**M54 to M6 Link Road**  
**TR010054**

**8.8 LA(B) Draft Statement of Common  
Ground with South Staffordshire  
Council**

**8.8 LA(B) Draft Statement of Common Ground with  
South Staffordshire Council**

## STATEMENT OF COMMON GROUND

Drawing file: TR010054 / TR010054-001020-TR010054 M54 6.3 Figure 2.7 Draft Masterplan Sheet 5 of 5.pdf

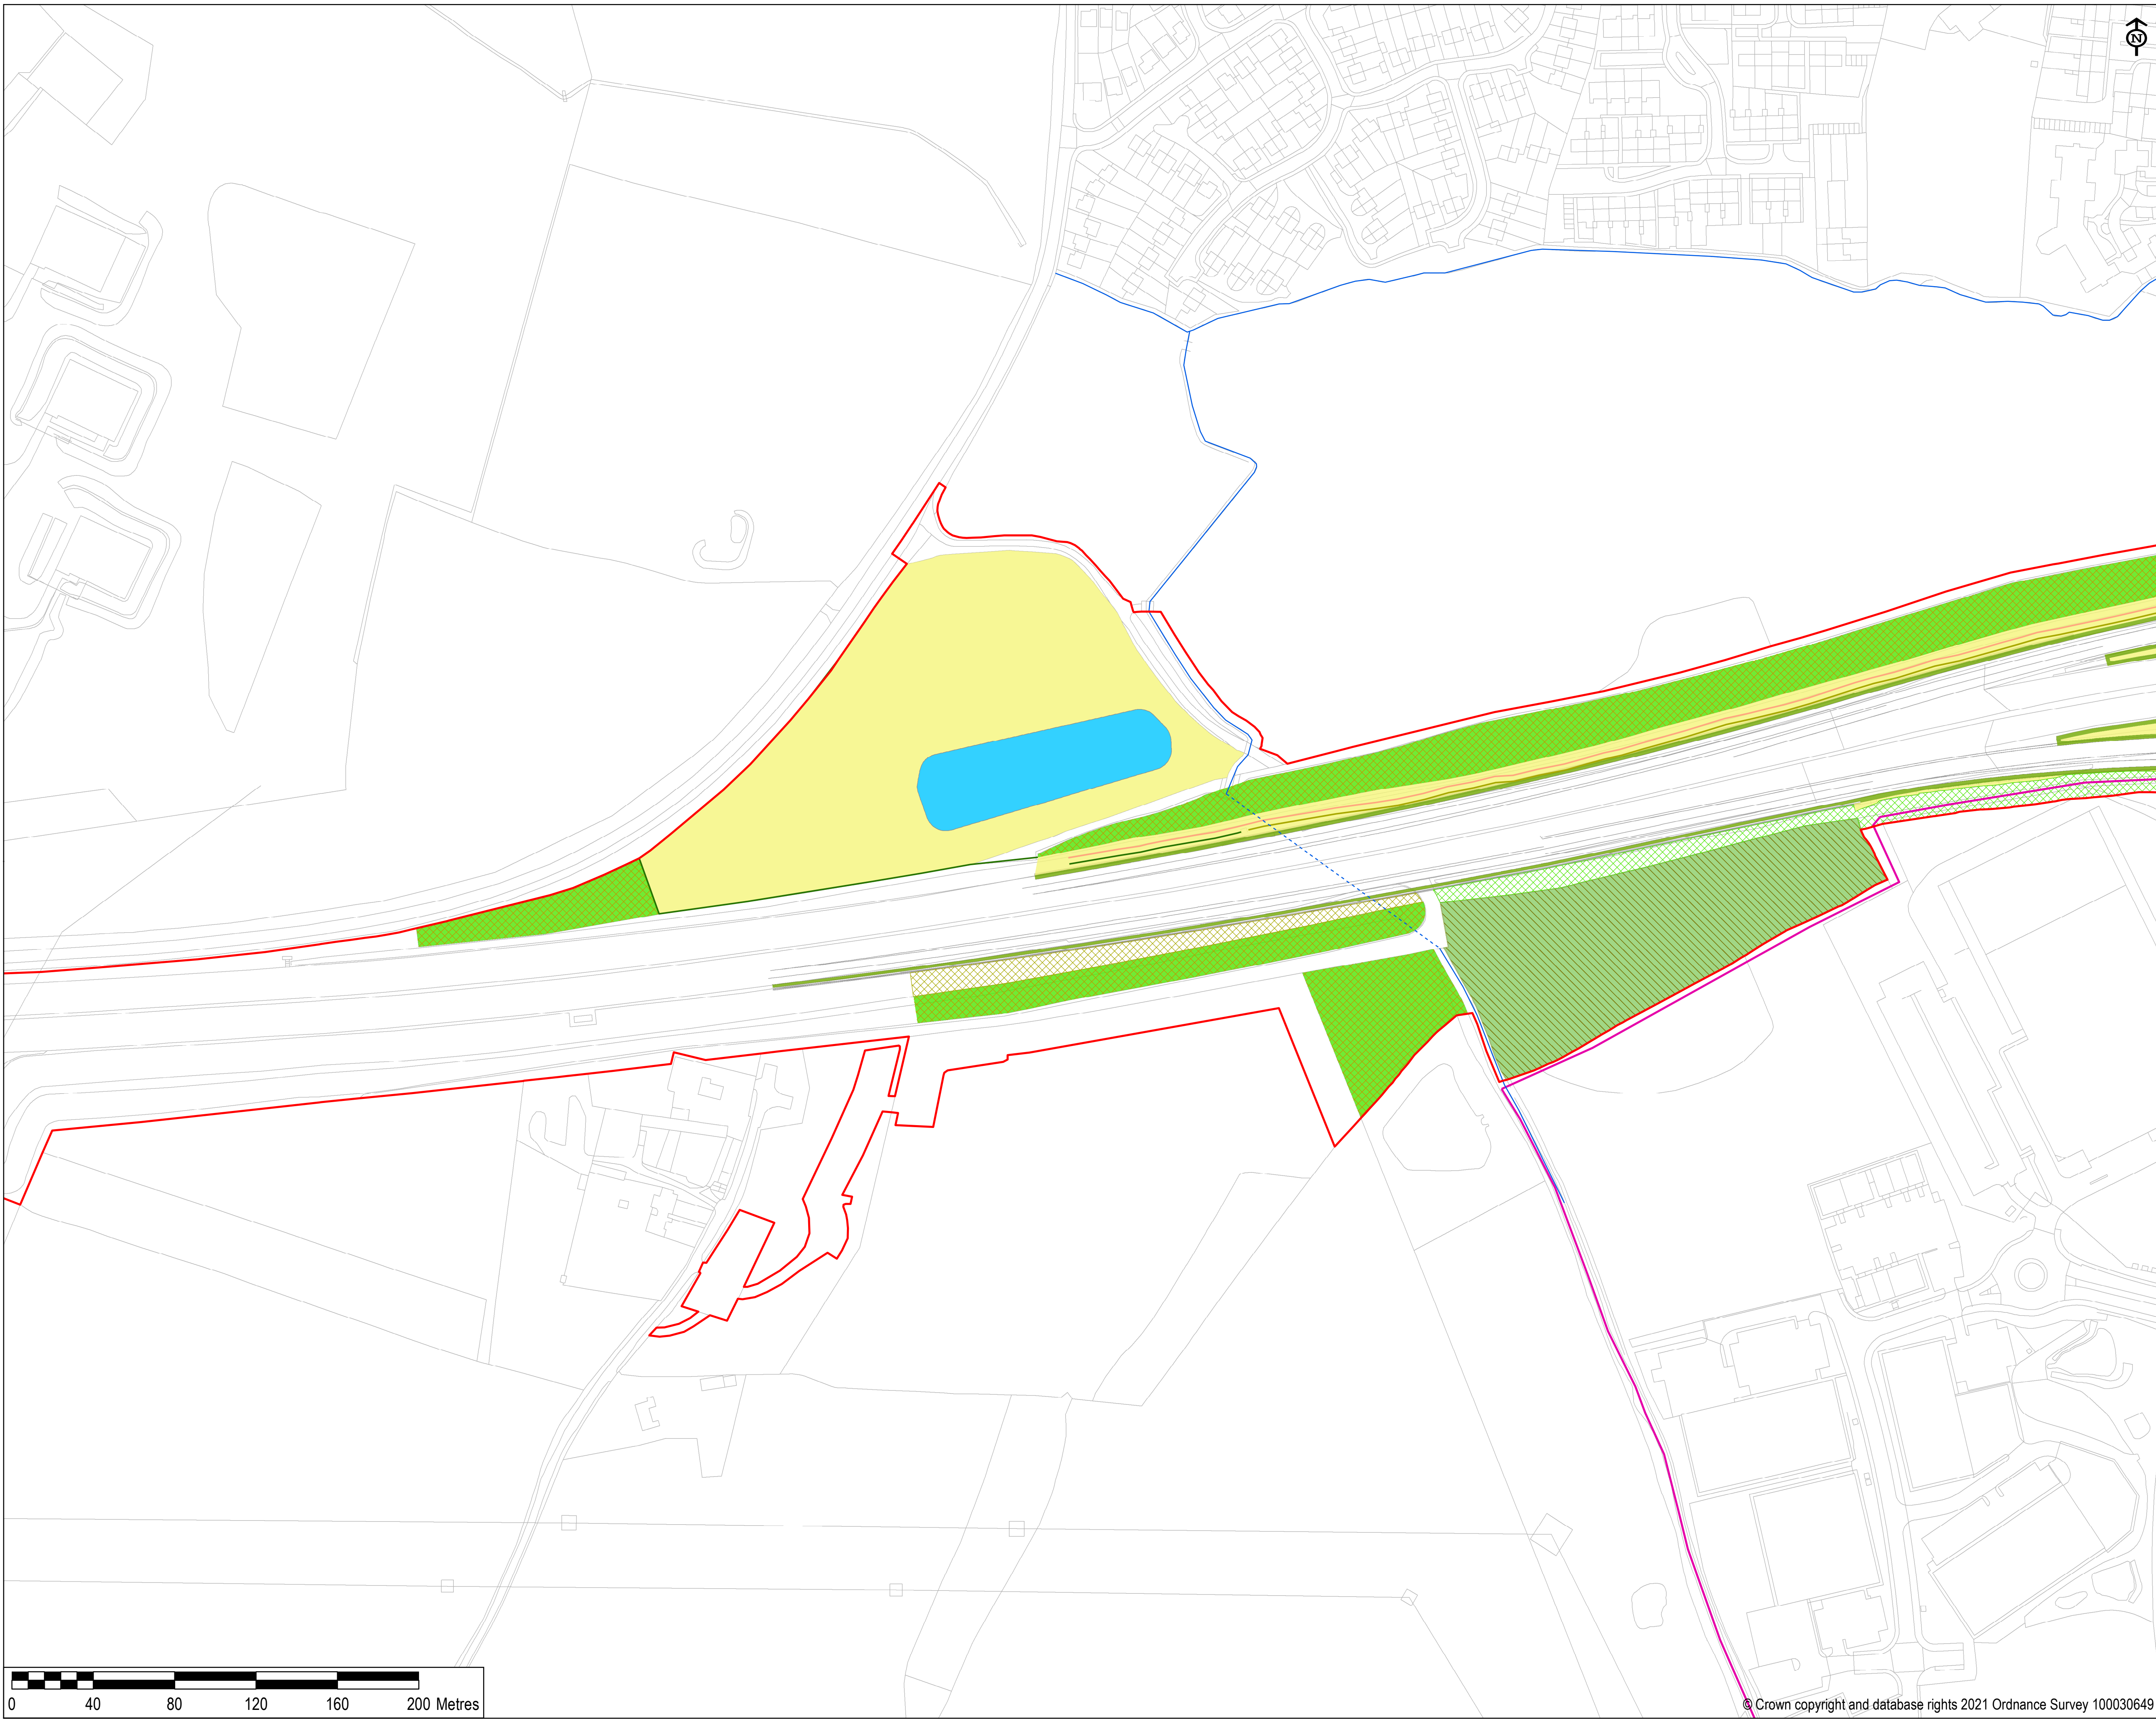
Environmental Masterplan (proposed changes version)	Scheme changes submitted 9 October 2020	Originally the field south of Dark Lane was to be planted however the recent Environmental	The Scheme changes were accepted by the ExA on 29 October 2020.  The reduction in environmental mitigation proposed in the Scheme changes is as a result of the reduced	Under discussion	Medium

<p><b>[AS-086 to AS-092/6.2]</b></p>		<p>Masterplan shows that this site is no longer within the Order Limits and therefore planting within this area is no longer proposed.</p> <p>The land north of Dark Lane was also to be planted with woodland entirely, however the recent Environmental Masterplan shows a significant reduction, this is somewhat disappointing. For further biodiversity gains along with improvements to landscape character and residential visual amenity we request further woodland planting is reconsidered in line with the County Ecologists recommendations.</p>	<p>impact of the Scheme on existing habitats, additional survey results and more detailed ecological assessment.</p> <p>The area to the south of Dark Lane was proposed to be used as a Great Crested Newt (GCN) receptor site for holding GCN during the construction of the works as well as providing part of the permanent mitigation for the loss of ponds assumed to support GCN. Four ponds affected by the Scheme could not be surveyed in 2018/2019, it was therefore assumed that these four ponds supported GCN and would need to be replaced at a ratio of 2:1 (as required by Natural England).</p> <p>Following the results of the Spring 2020 GCN surveys it was found that none of the ponds lost during the construction of the Scheme support GCN and therefore these ponds are only required to be replaced on a like for like basis (a total of eight ecology ponds).</p> <p>As the receptor site is no longer needed during the construction of the Scheme and there is a reduced need to provide replacement pond habitats, the three ecology ponds in this area and the associated terrestrial habitat included primarily to mitigate impacts on GCN are no longer required.</p> <p>In terms of using the area to the north of Dark Lane to deliver biodiversity net gains, it should be noted that HE is seeking to acquire land for the Scheme through compulsory acquisition. In order to secure those powers, Highways England must demonstrate that the land subject to compulsory</p>

<p>acquisition is required for the Scheme or is required to facilitate or is incidental to the Scheme (section 122 of the PA 2008). This means that, whilst land required to mitigate the impact of the Scheme can be secured through compulsory acquisition, such powers do not extend to the acquisition of land solely for delivering biodiversity net gain. Unfortunately, this means this justification is unlikely to be sufficient to retain the whole of the field for planting.</p> <p>Highways England is nonetheless seeking to fully mitigate the impact of the Scheme on biodiversity by delivering no net loss in biodiversity. Both the original Scheme and the Scheme as amended by the documents submitted on 9 October 2020 would fulfil this aim, as shown in Appendix 8.2 Biodiversity Metric Calculations [TR010054/APP/6.1] versions 2 (unchanged Scheme) and 3 (Scheme changes version).</p>		
<b>3. Effect on Cultural Heritage</b>
